**ADC Planning Consultation
Conservation/Design Officer Response**

Application Number	Y/92/17/OUT
Address	Land east of Drove Lane Yapton BN18 0EB
Description	Outline application with all matters reserved save access, for up to 300 dwellings, link road, surface drainage, open space and landscaping. Departure from the Development Plan and Access route is within the Yapton (Main Road) Conservation Area
Case Officer	Mr D Easton
Date	30 th January 2018

FIGURE 36. Indicative cross sections showing relationship between the proposed housing and existing Listed Buildings in Main Road

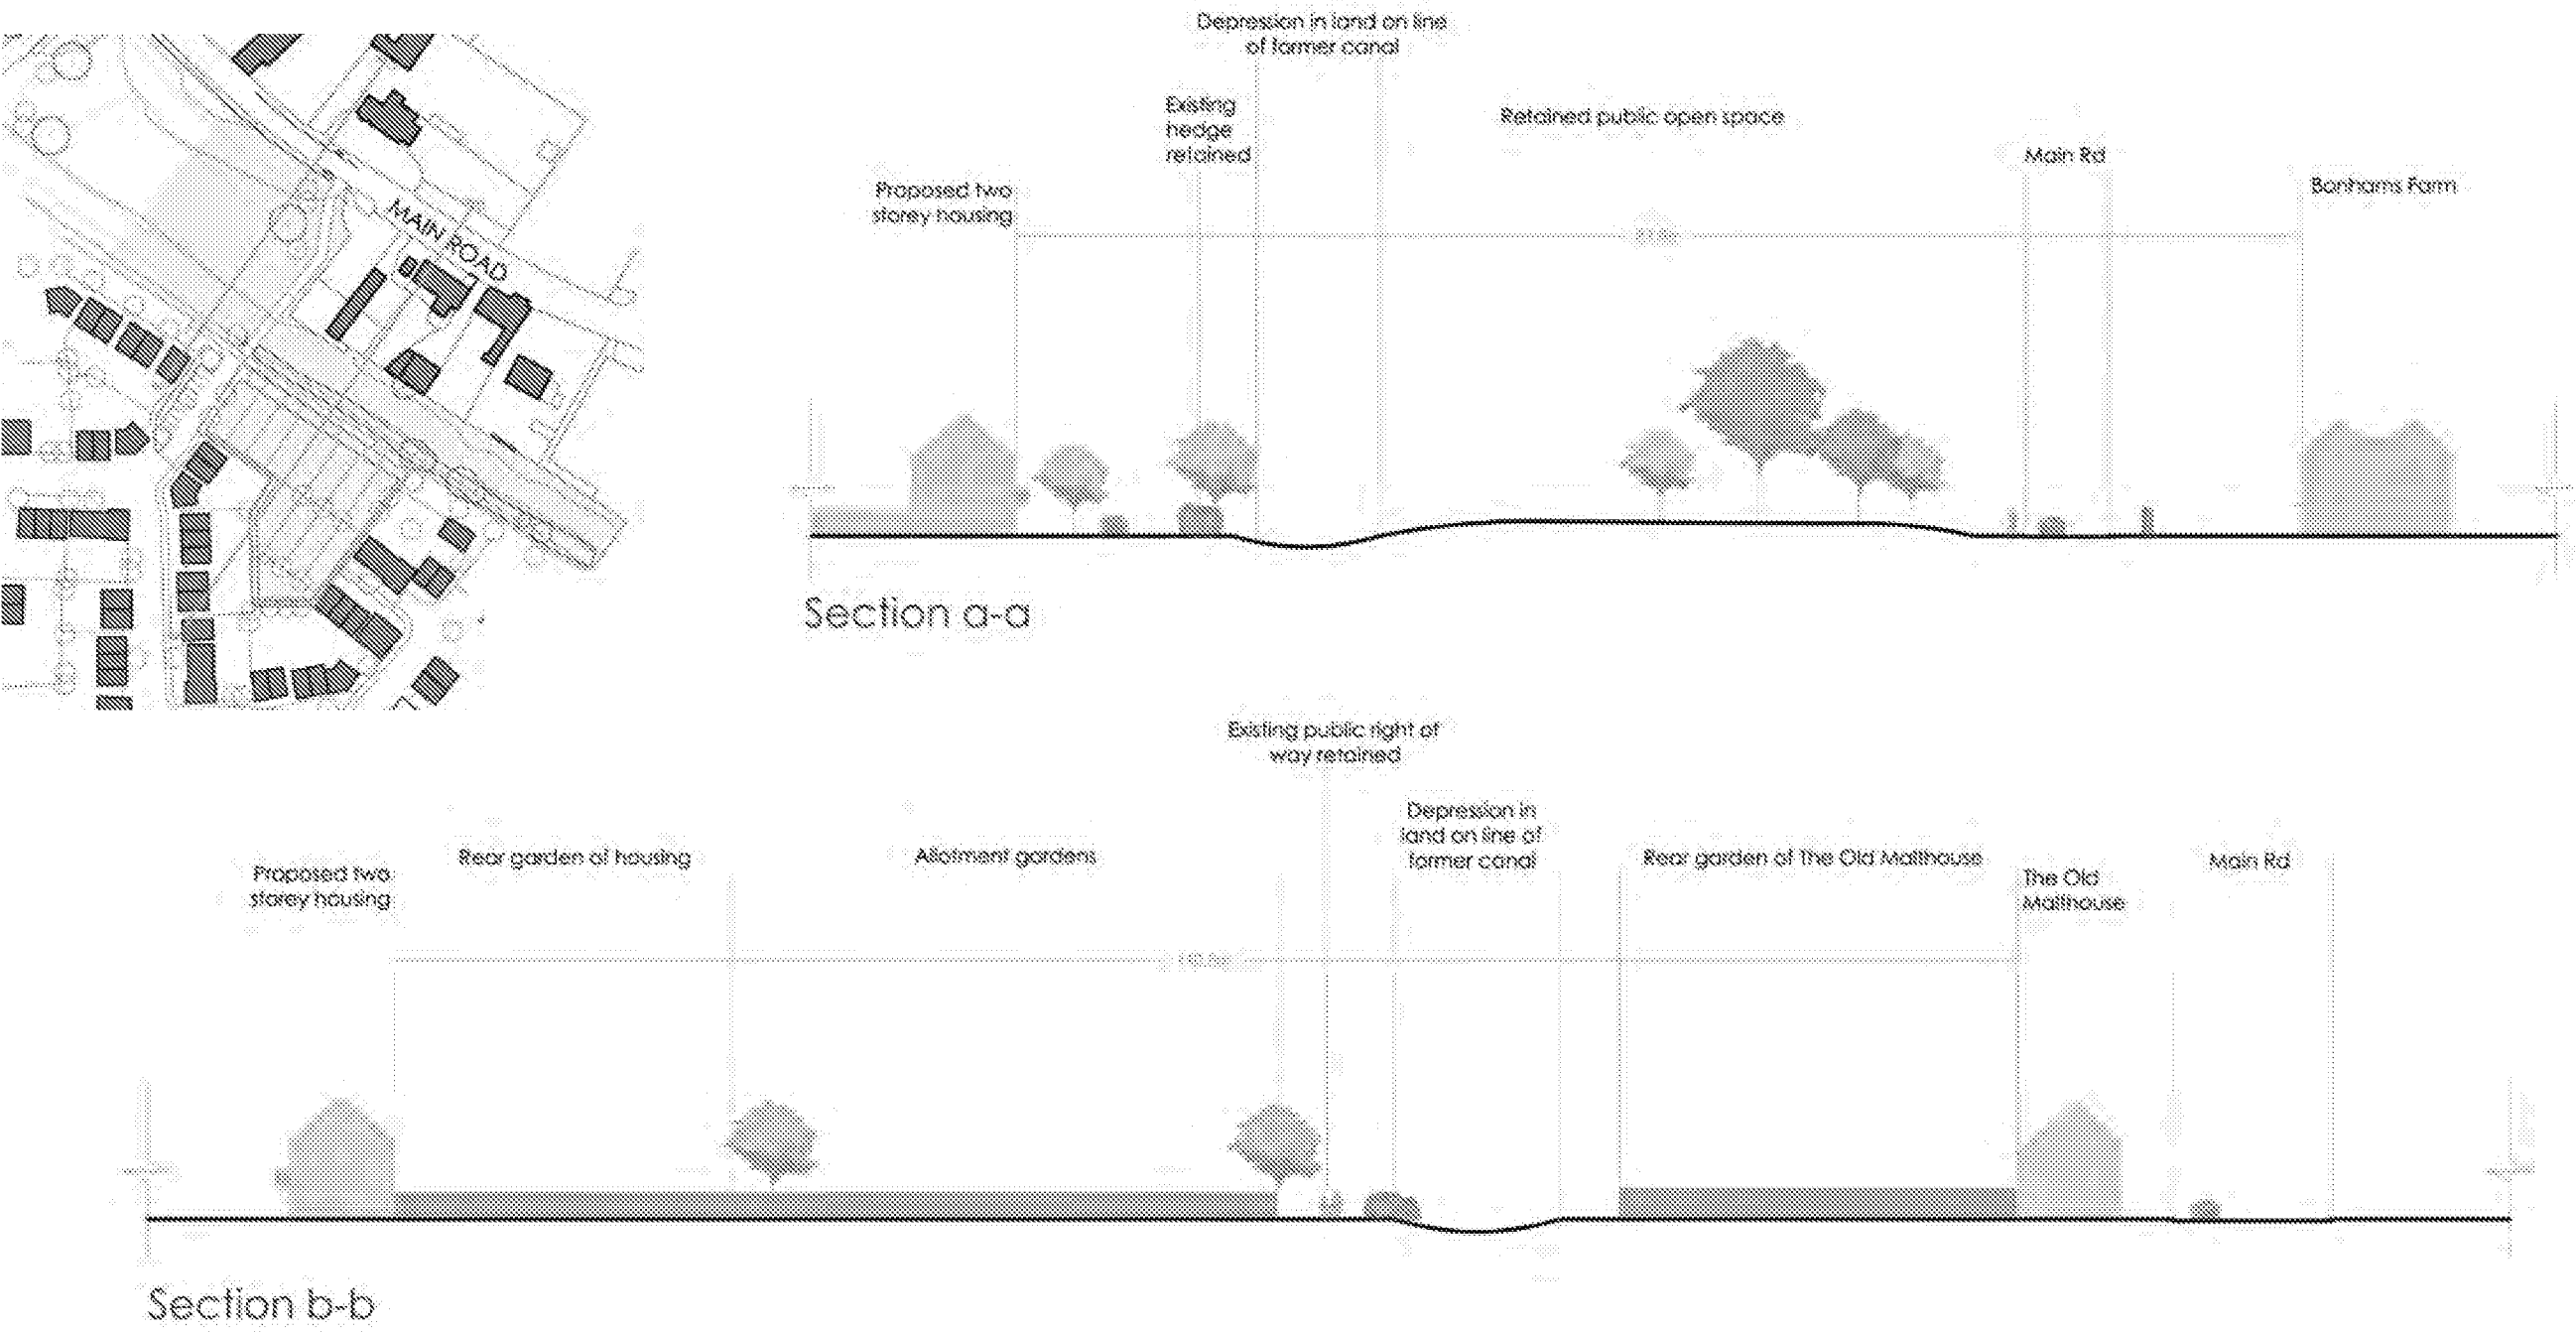
The proposals would have an impact on the setting of the listed buildings as detailed above, and on the Conservation Area. Views both in and out of a Conservation Area are material considerations, and the proposal would be to the detriment of this enjoyment, especially from footpaths crossing the proposal site, and from the path following the course of the Chichester and Arundel Canal.

It is accepted that 'Green Infrastructure' as noted on the submitted plans would go some way to shield the proposed development from the listed assets and the wider Conservation Area, but would have a negative impact upon its setting and wider enjoyment and does erode the SW extent of the Conservation Area. In particular, the proposed vehicular access to Main Road would intrude into the setting of the Listed Bonhams and the Conservation Area through which it passes. The character of Drove Lane would be eroded by the introduction of visibility splays, together with proposed widening of Drove Lane.

From a heritage perspective, there are objections to the proposal in general terms, relating to the relationship of the proposal site to the Listed Buildings, historic landscape and Conservation Area as described above. It should be noted that the
